Re: Application 6/2016/1855/VAR

Further to your recent notification concerning the above application and that the appellant has applied to remove condition 2 (obscured glazed dormer windows) we note that the appellant has now issued a window detail and we would respond as follows.

North Facing Elevation windows

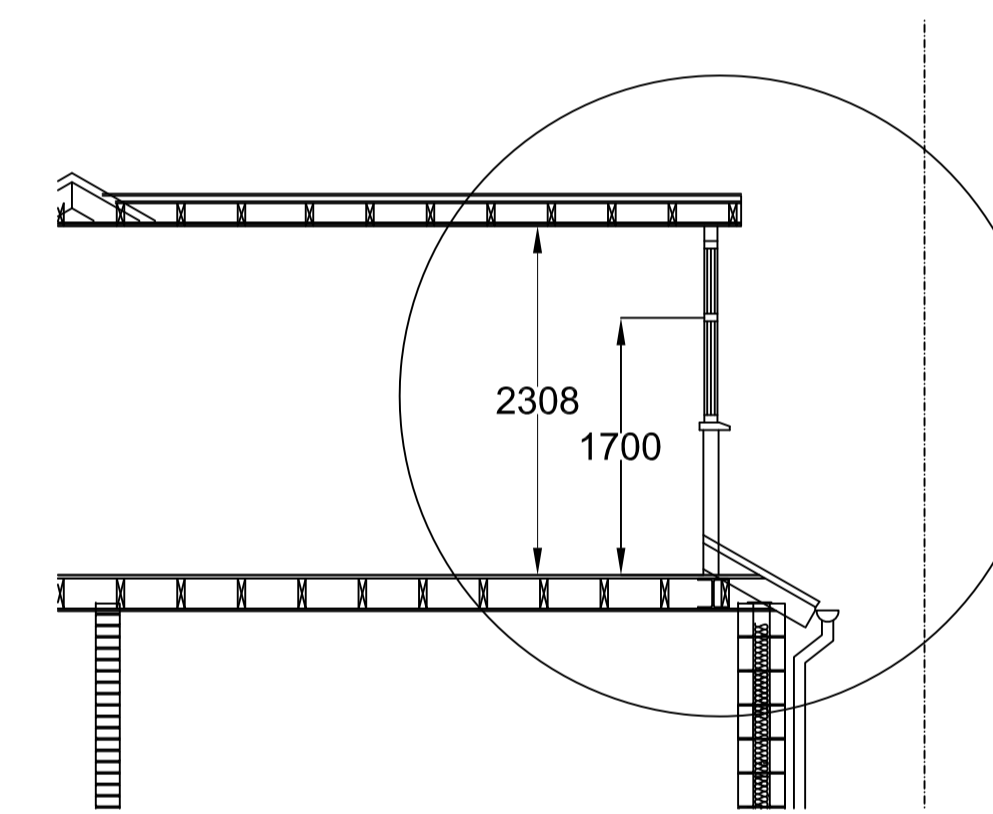
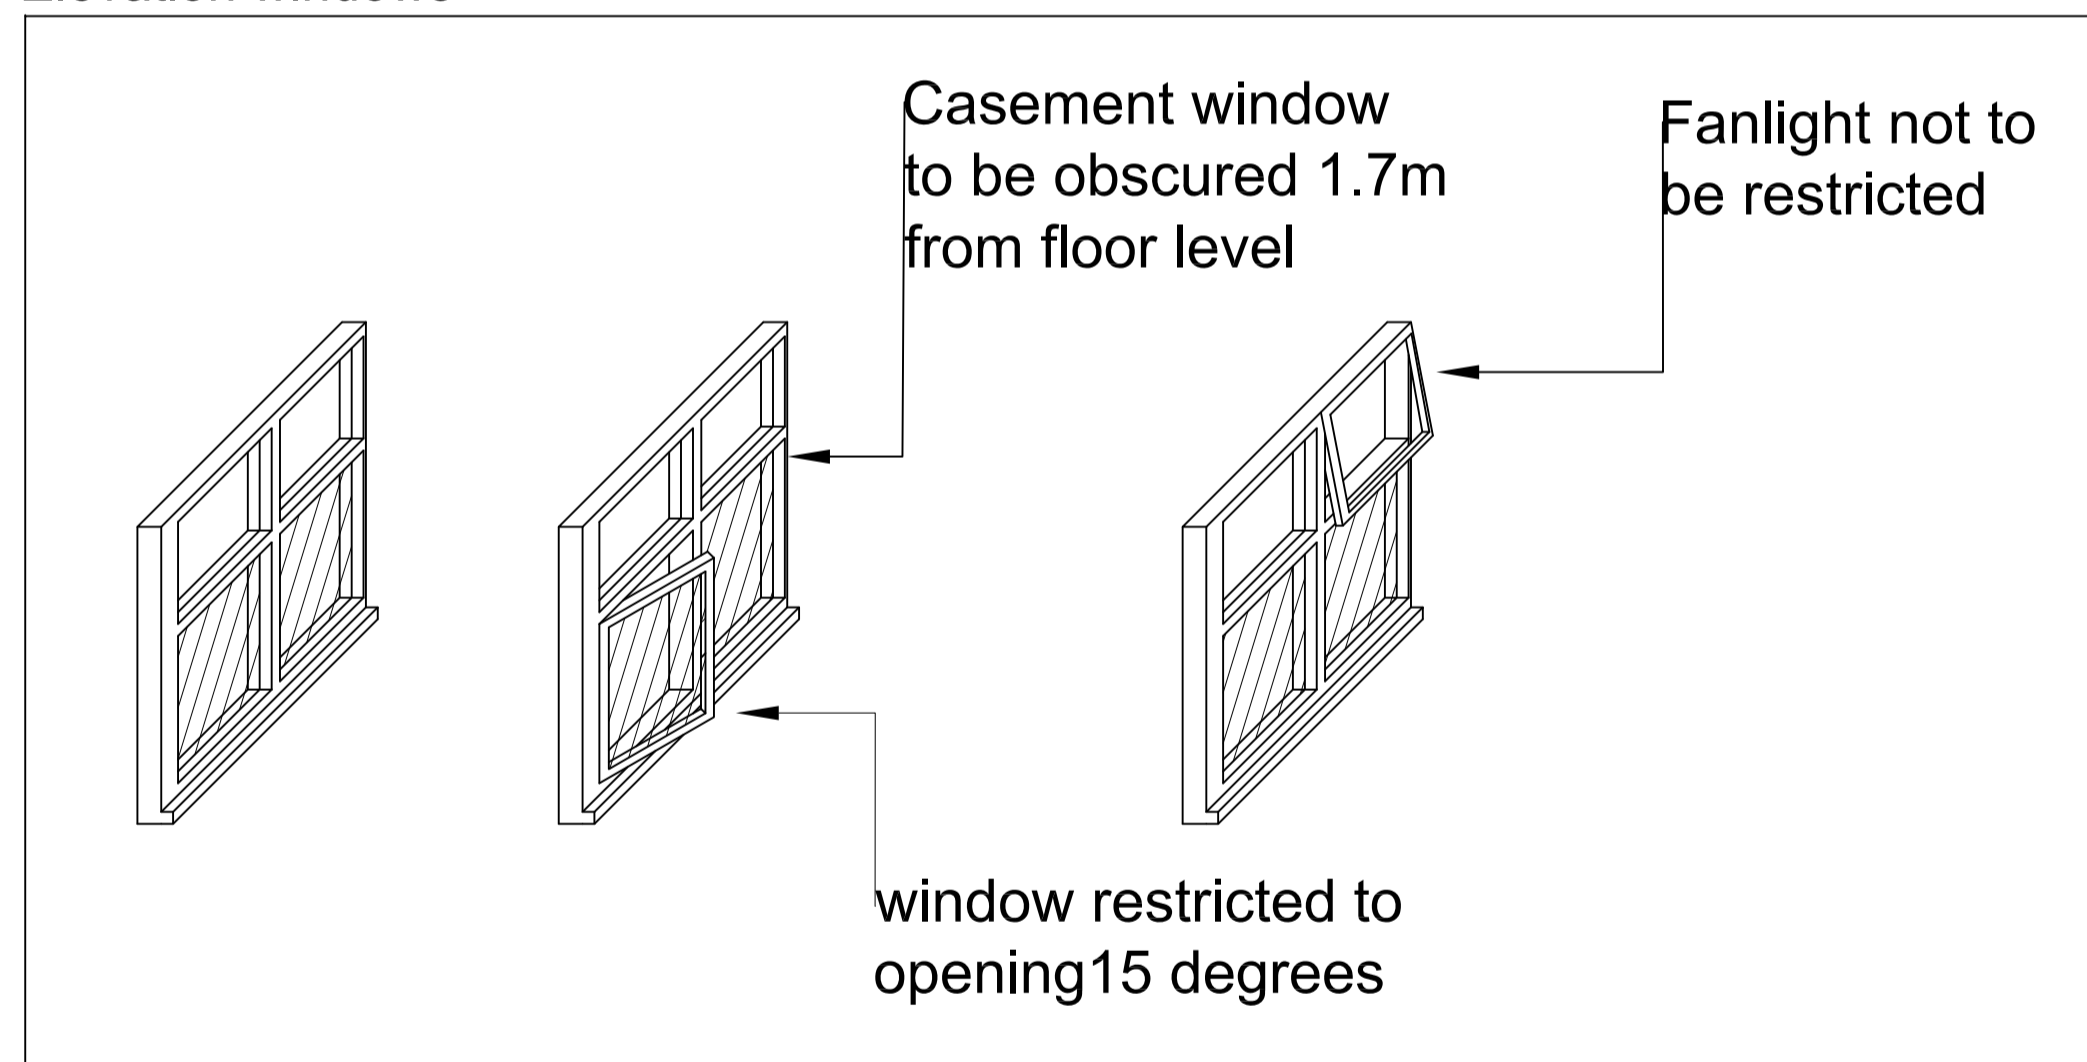
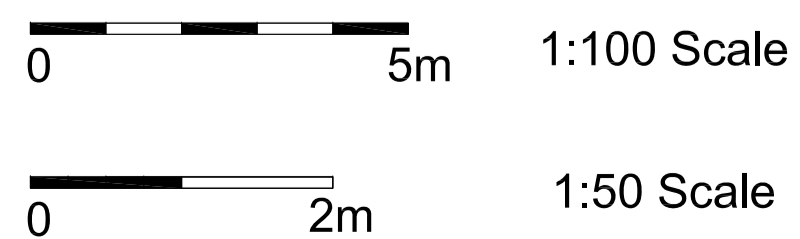
There is no need for restrictors on the windows. If it is suggested that these are required for ventilation purposes or so that in event of a fire the windows can be opened then I would point out that there are other means of ventilation and escape. A Juliet balcony to the rear of the property, large window to the front and also a number of roof lights in the roof slopes. It should also be pointed out that the windows are fitted with trickle vents which complies with Building Control regulations.

The Condition pertaining to the Planning Permission states “all side facing dormer windows of the building shall be glazed with obscured glass and shall be fixed as to be incapable of being opening below a height of 1.8m above the floor level”. The drawing shows the fanlights are at 1.7m above the floor level, therefore these should be fixed and obscured in line with the condition.

We are not aware of a “general acceptance” by all Local Authorities as to 1.7m above finished floor level for obscure glazing.

Please also note that at 1.7m this would allow an average height person the opportunity to look through the fanlight straight into our bedrooms which as previously documented is not acceptable.
